**EL PASO COUNTY PLANNING AND  
 COMMUNITY DEVELOPMENT  
 DEPARTMENT**

**STORMWATER MANAGEMENT PLAN CHECKLIST**

**The Hills at Lorson Ranch**

SEE SHEET C4.6

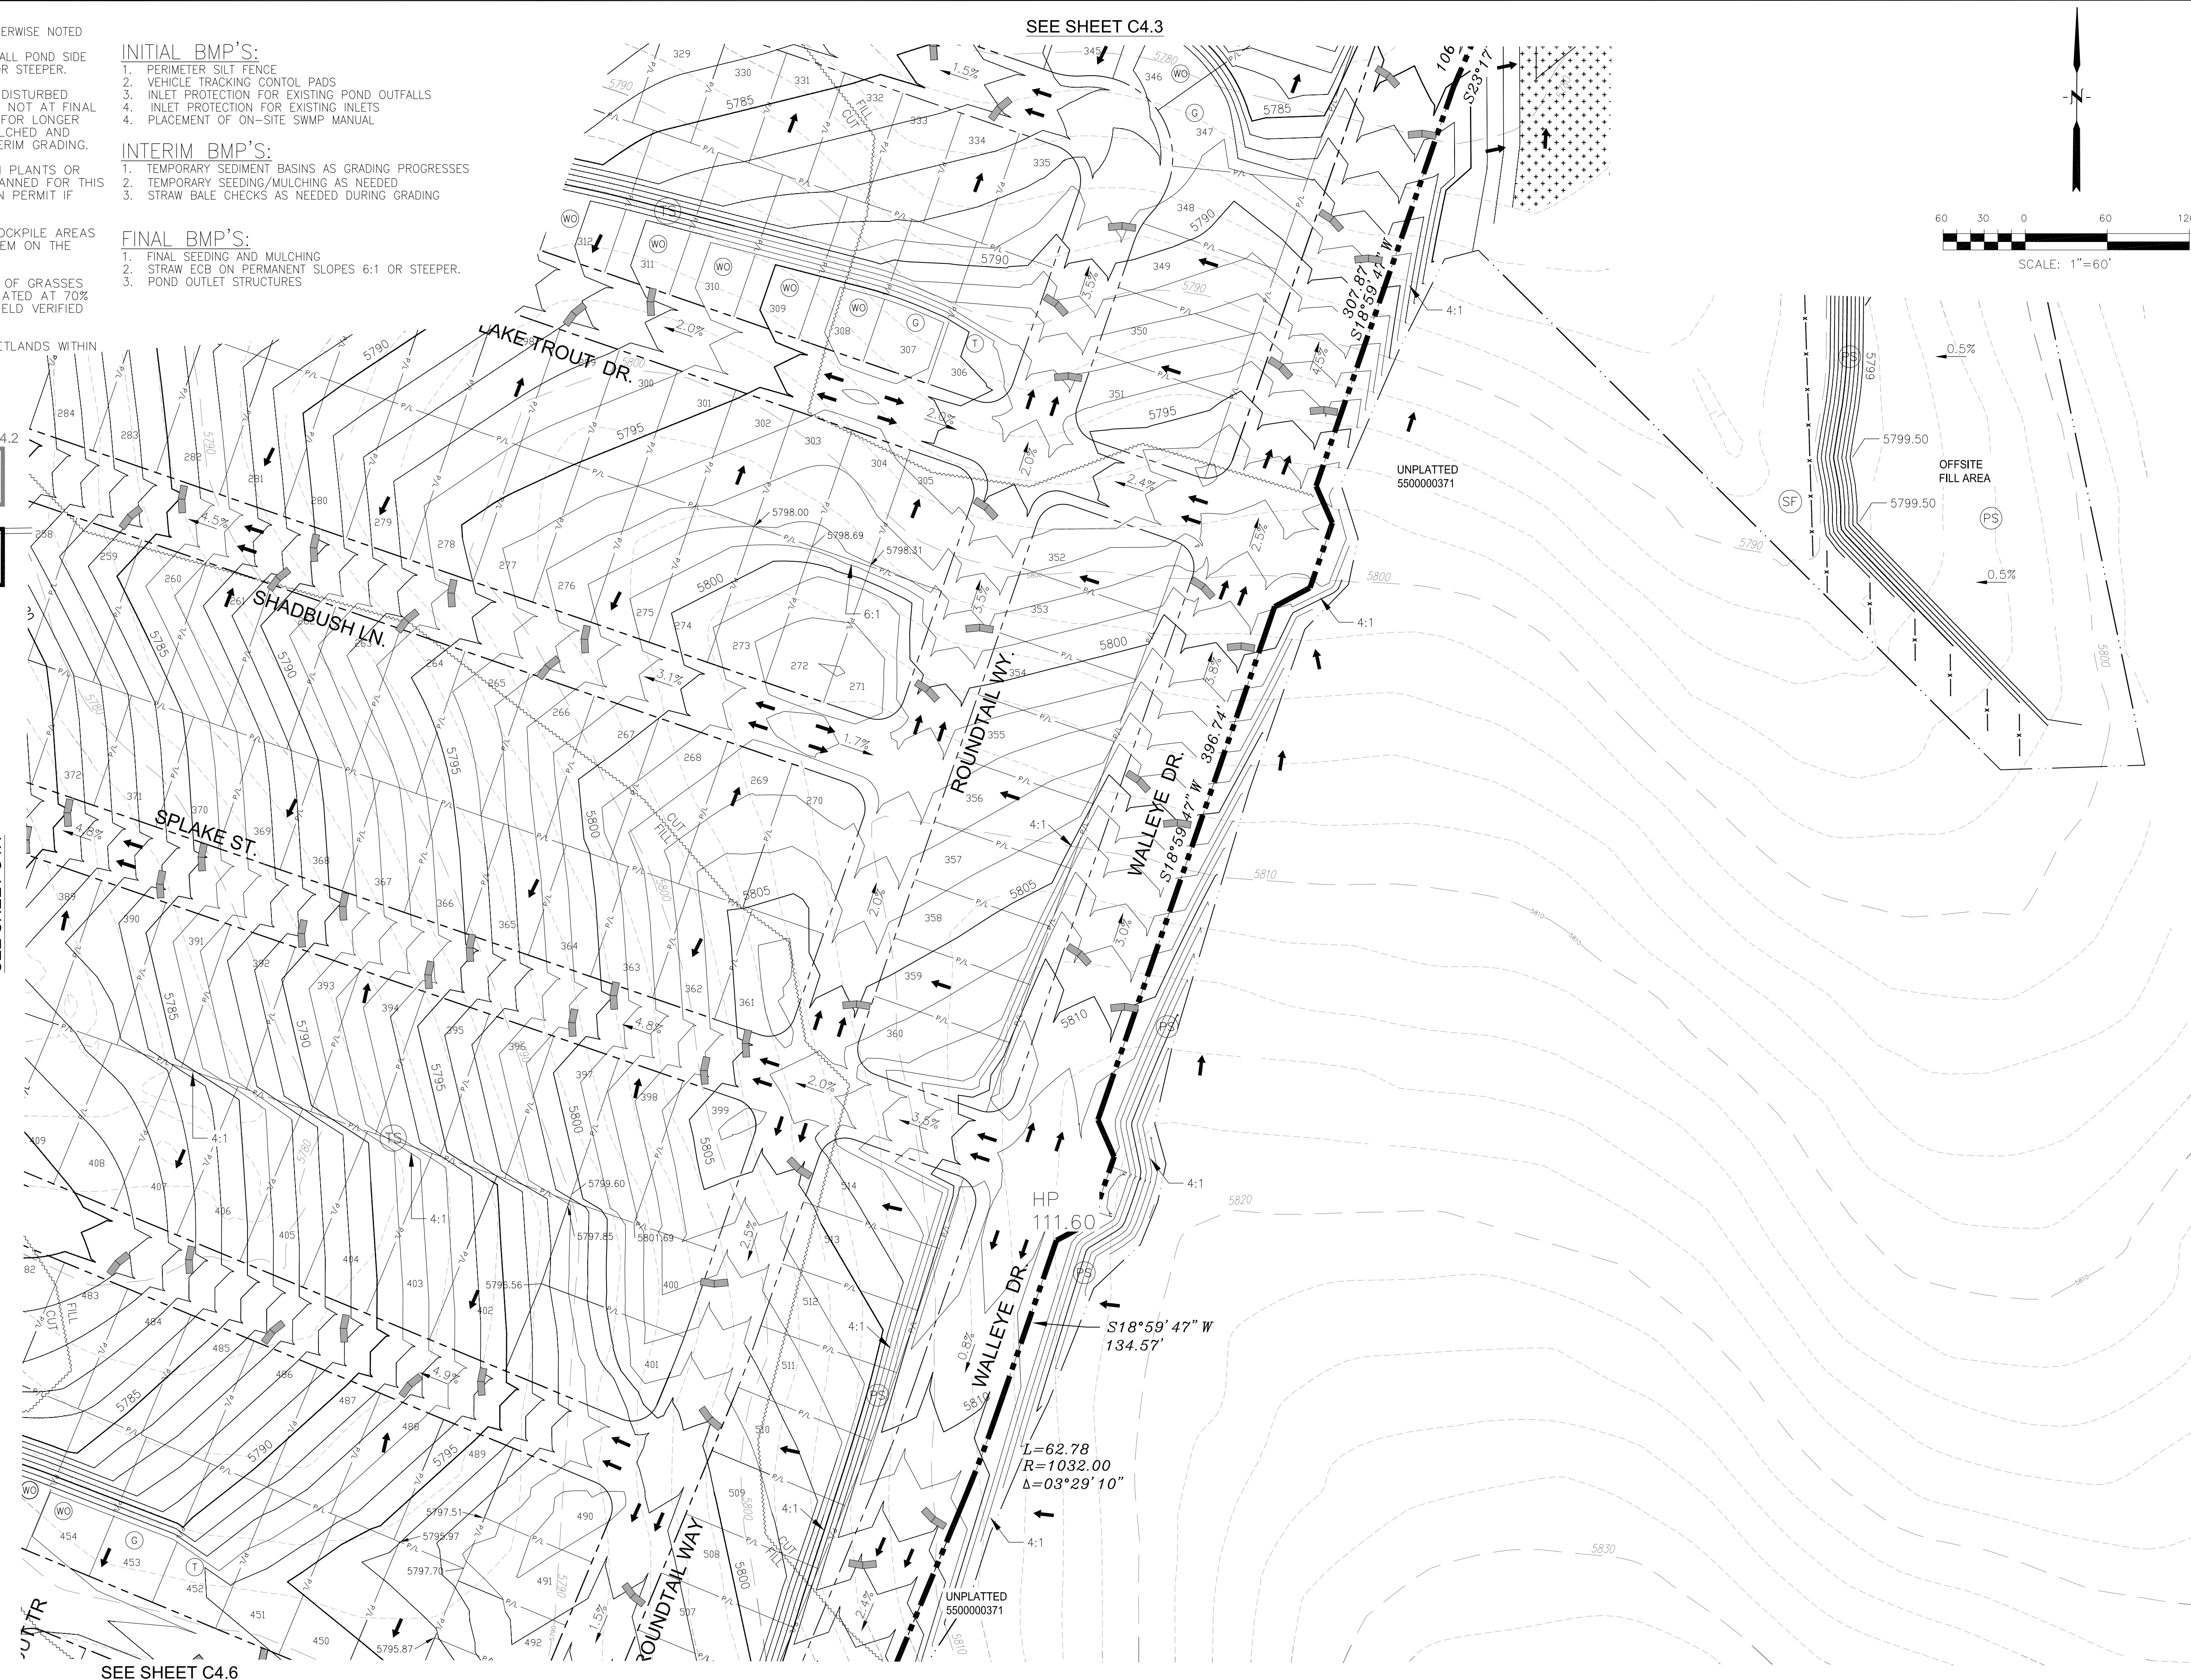
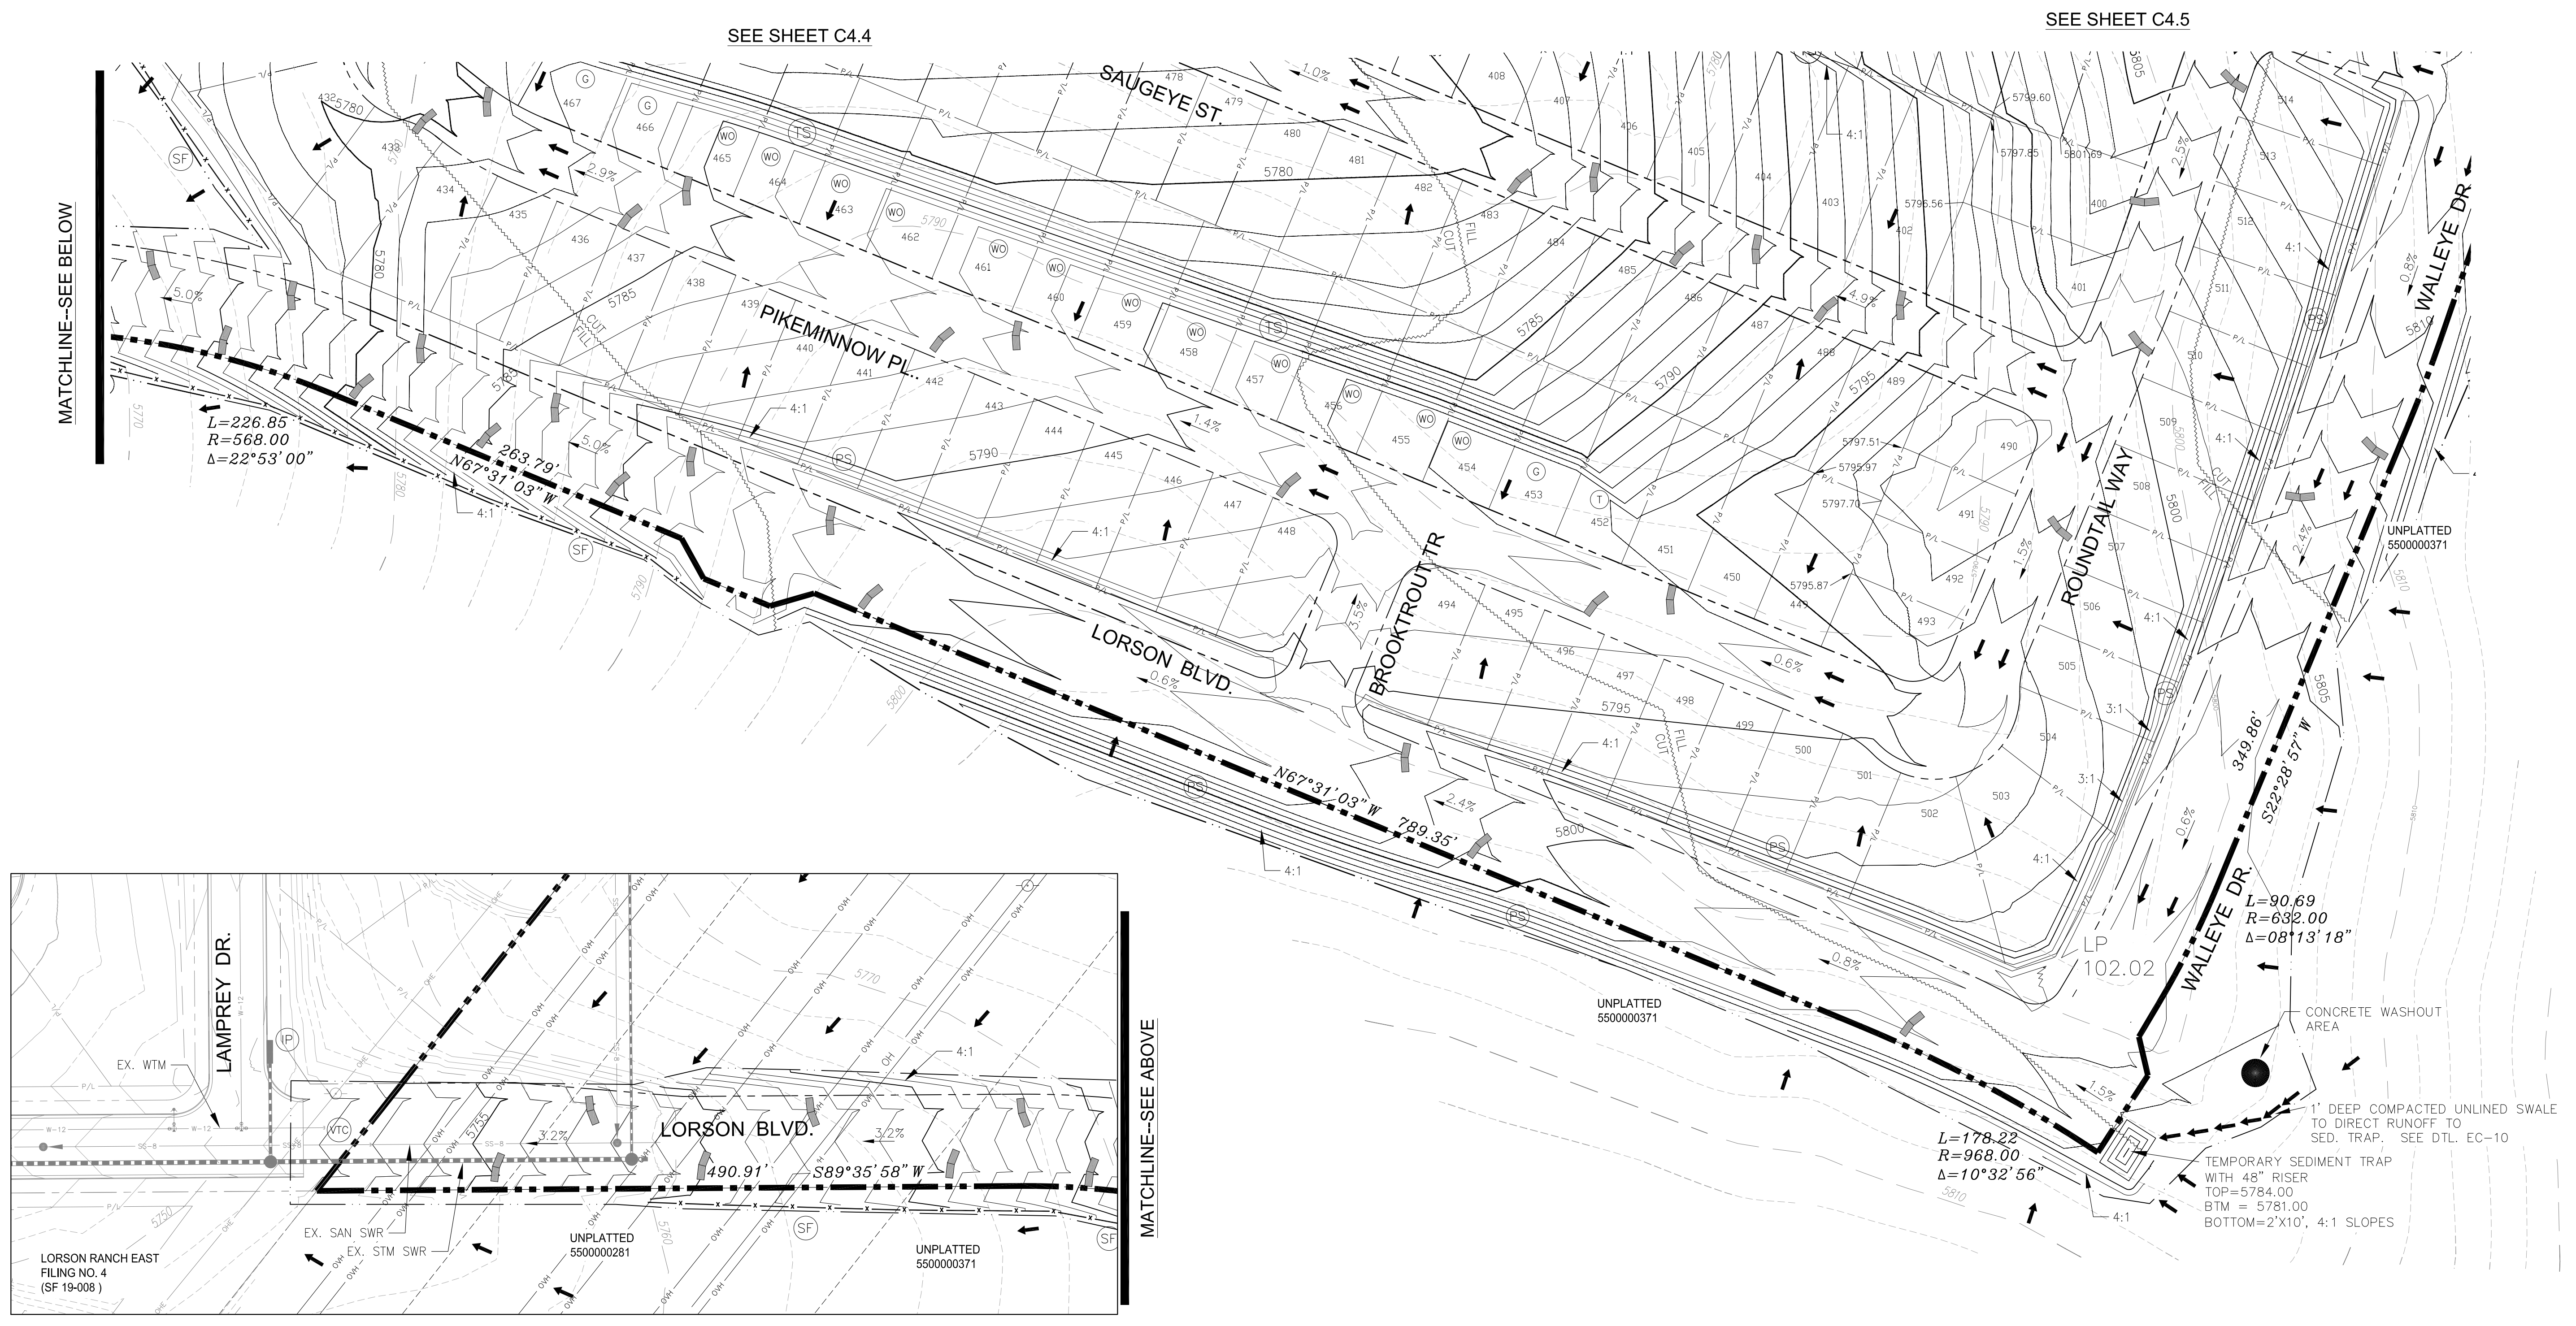
Applicant	PCD
17	SWMP Map to include: <b>Reviewed GEC Plan V_1</b>		
17a	construction site boundaries	y	✓
17b	flow arrows to depict stormwater flow directions	y	✓
17c	all areas of disturbance	y	X
17d	areas of cut and fill	y	✓
17e	areas used for storage of building materials, soils (stockpiles) or wastes	y	✓
17f	location of any dedicated asphalt / concrete batch plants (No batch plants on-site)	n/a	✓
17g	location of all structural control measures	Y	✓
17h	location of all non-structural control measures	Y	X
17i	springs, streams, wetlands and other surface waters, including areas that require maintenance of pre-existing vegetation within 50 feet of a receiving water (No areas require maintenance of pre-existing vegetation)	n/a	✓
18	Narrative description of all structural control measures to be used. Modifications to EPC standard control measures must meet or exceed County-approved details.	y	✓
19	Description of all non-structural control measures to be used including seeding, mulching, protection of existing vegetation, site watering, sod placement, etc.	y	✓
